Your Ref: OWQC20684
Our Ref: BR/283/18/PL
Please ask for:
Mr S Davis

Enlarge dormer to the bay roof on north, ground floor windows & doors & railings to west elevation. This application affects the character & appearance of The Steyne, Bognor Regis Conservation Area.

Central House 18 Waterloo Square Bognor Regis

PROPOSED WEST ELEVATION

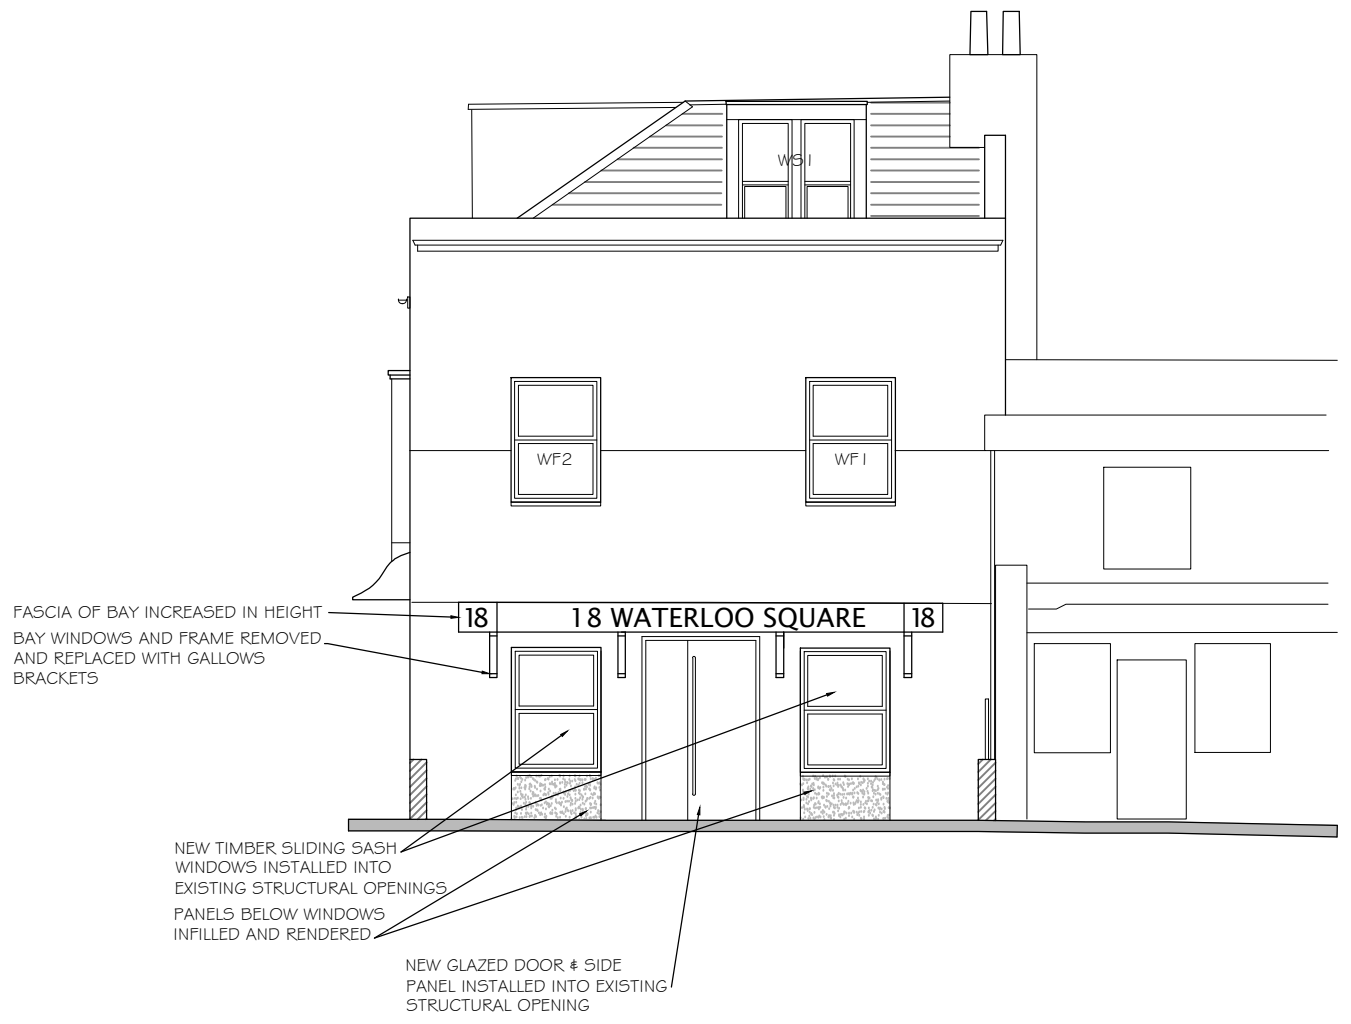
OBJECTION The proposed changes to the existing west elevation of the building would adversely affect the character and appearance of Waterloo Square which lies within The Steyne and Waterloo Square Conservation Area.
